H O L L A N D
DISTRICT COUNCIL

Application no: H18/0665/00

Description: Erection of two houses with
associated parking.

Location: Land adj. 1 Youngs Row
Sutton Bridge
Spalding
Lincs

ERECTOR OF TWO HOUSES WITH ASSOCIATED PARKING
ADJACENT No. 1 YOUNGS ROW
SUTTON BRIDGE
Lincs
For PREMIER BUILDERS (South Lincs) Ltd
10 OCTOBER 2000
11 DEC 2000
0665460
APPROVED PLAN
Full Planning Permission: 11/00065/000 dated 04/08/2000
Building Regulation amendments: B1/00063/000 dated 16/11/2000

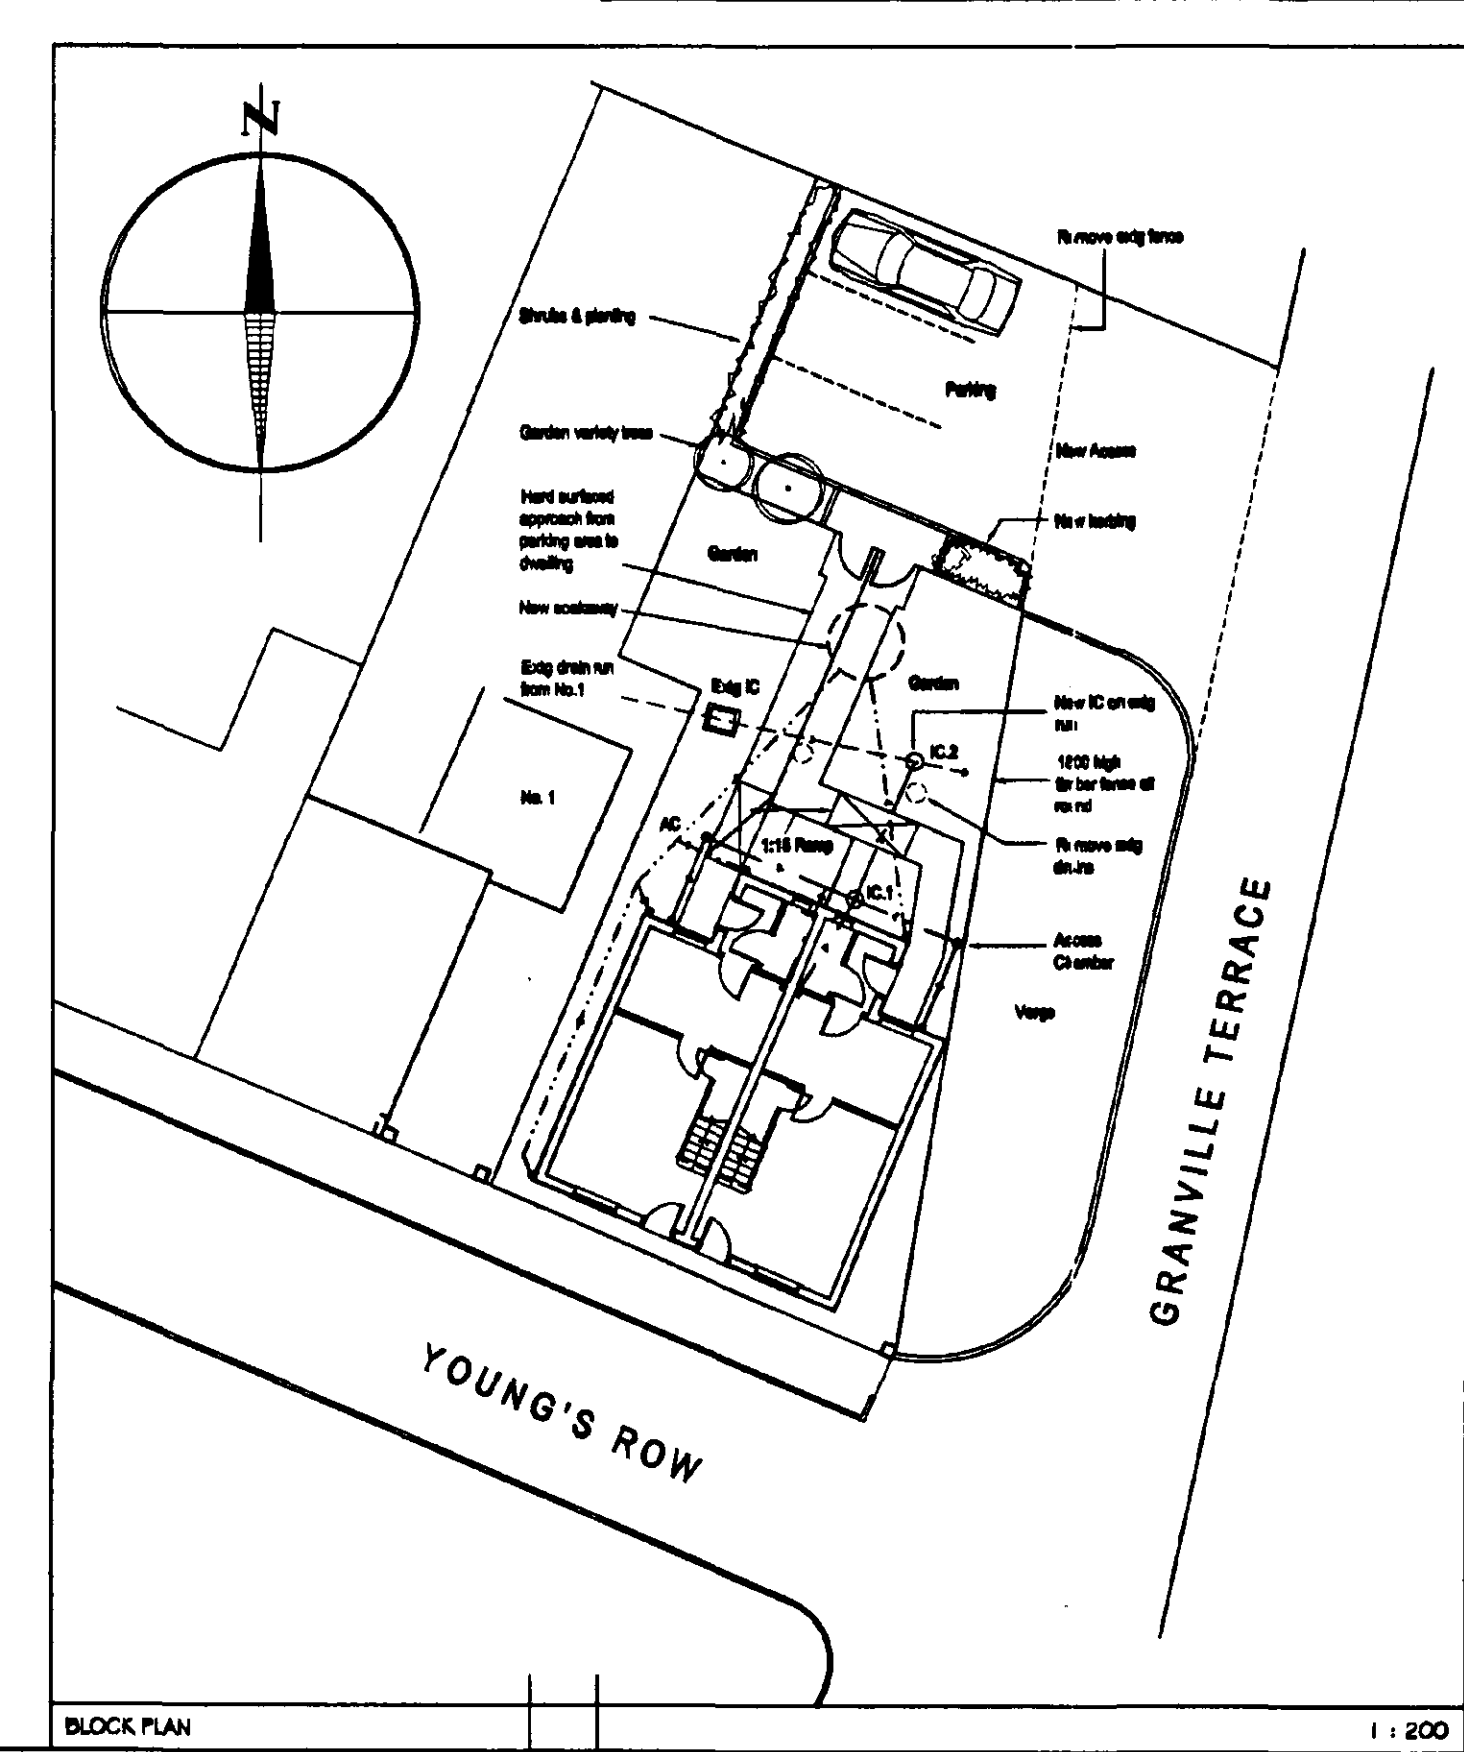
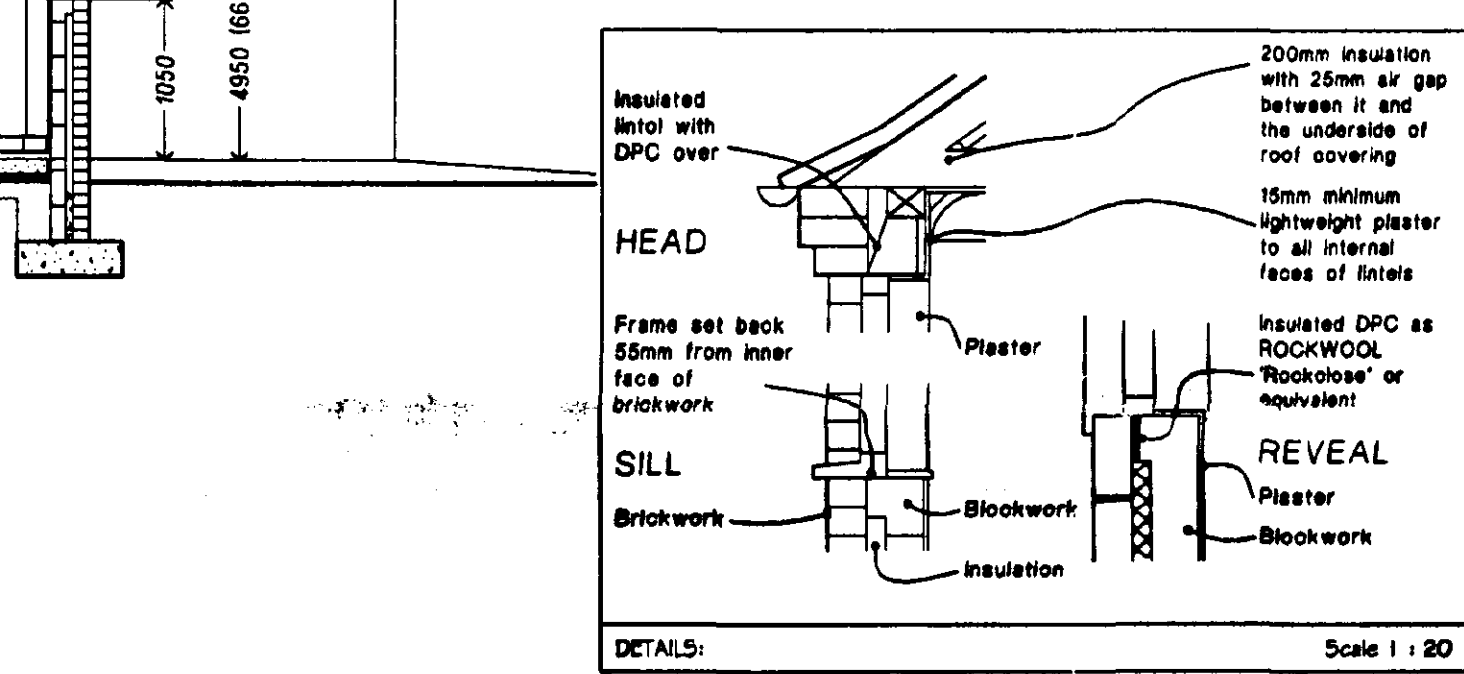
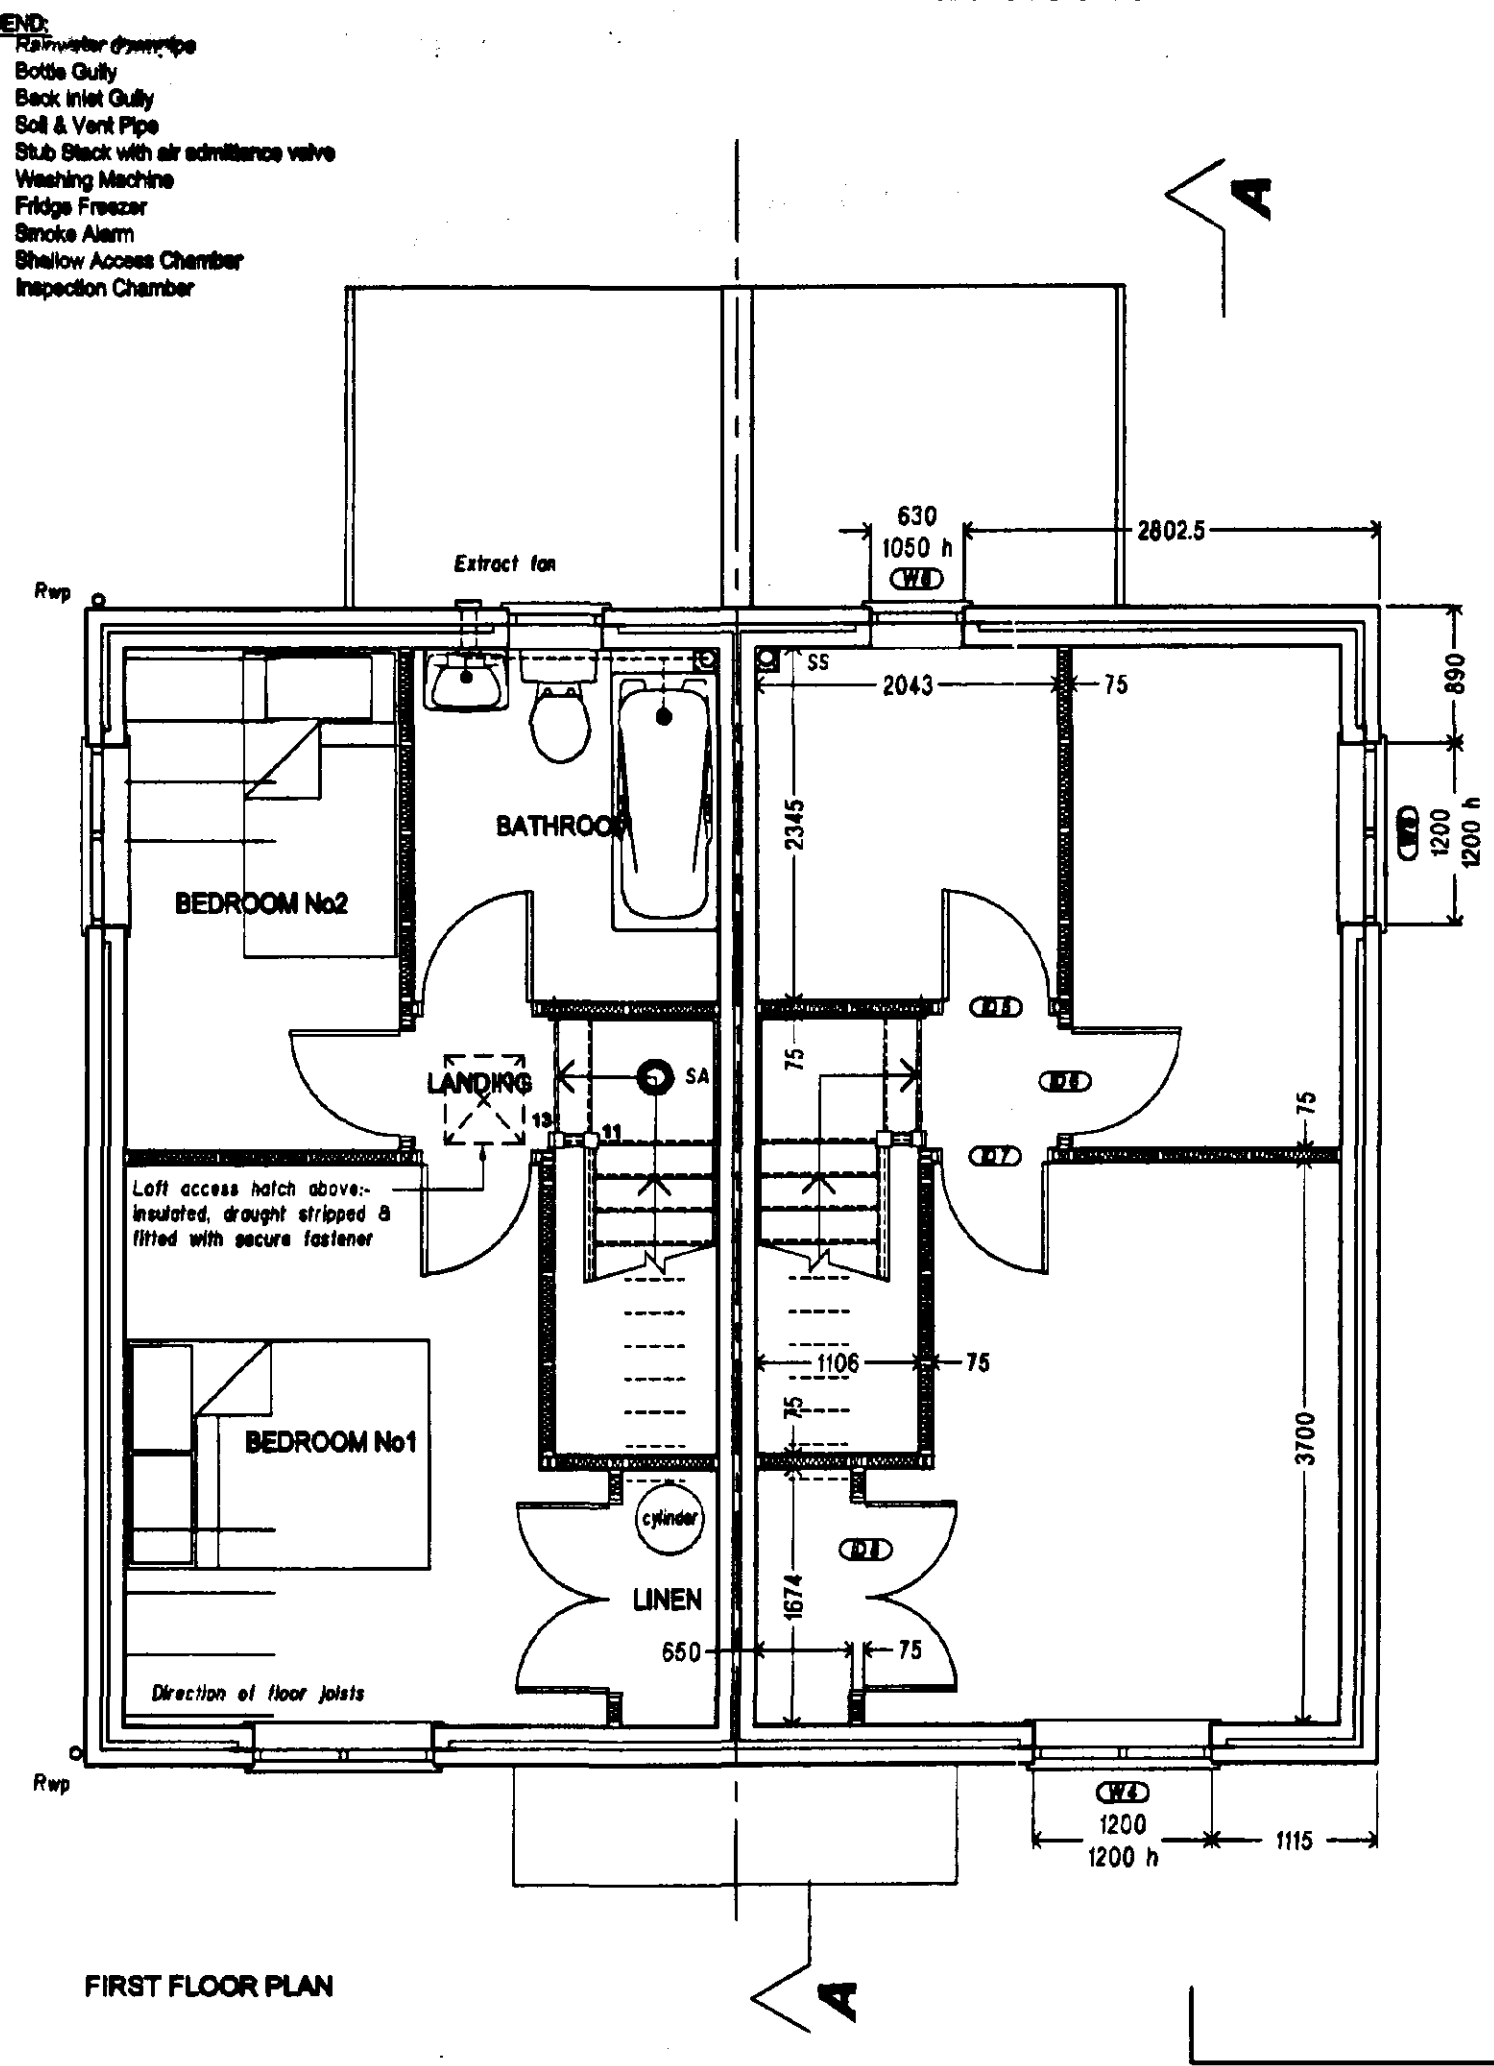
Amendment: Windows moved from north to east and west elevations

The amended details submitted in respect of the above proposal have been received and I consider that the changes are too significant to be treated merely as an amendment. A fresh application will therefore be required (forms enclosed). This does not imply that permission will or will not be forthcoming for any such revised application.

We bring to your attention that the windows which were originally located on the rear elevation, i.e. North, have been moved to the East and West elevations. This is due to revisions that had to be made to comply with the current Building Regulations, for 'escape windows'. The windows to both the Living Room and Bedroom No.1 have been altered in size to accommodate these requirements.
